May 9, 2014

Re: Watt Renovation  
Portland, Maine

Project Number: 14-027

3 KITCHEN
 A1 SCALE: 1/4" = 1'-0"

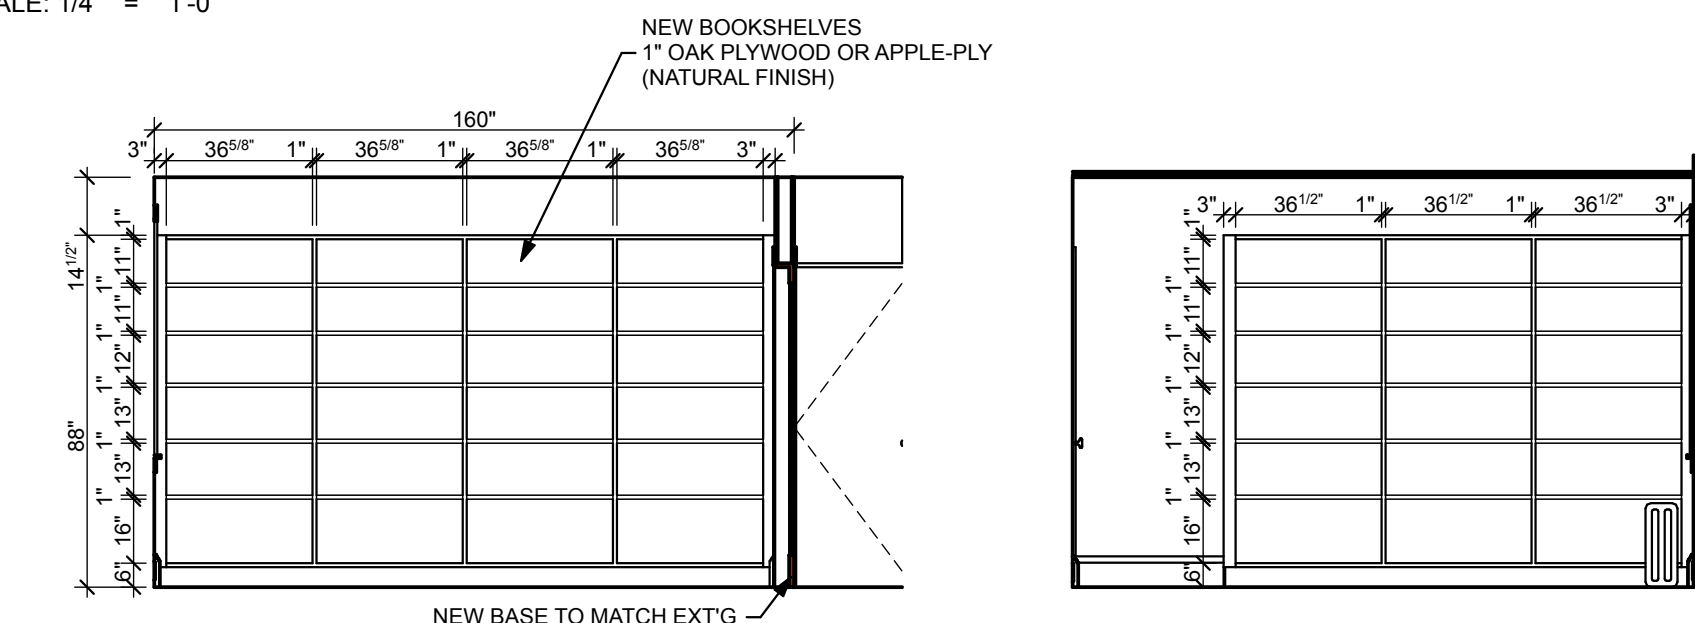
I met with Ray Keith at the site to discuss temporary support options during the proposed beam installation. We also discussed a steel beam option for the kitchen beam versus the LVL wood beam we originally specified. Per my discussion with Ray on site please find below the options for temporary support and a steel option for the kitchen header (approx. 10 ft. long).

Temporary supports can either be a 1 3/4"x11 7/8" LVL on both sides of the kitchen wall (as discussed in the field) or a C8x11.5 steel channel on both sides of the kitchen wall. The LVL option will need a minimum of six (6)-5/16" dia. RSS GRK screws at each end of each LVL support member.

The steel option for the kitchen header is a W8x15 steel beam.
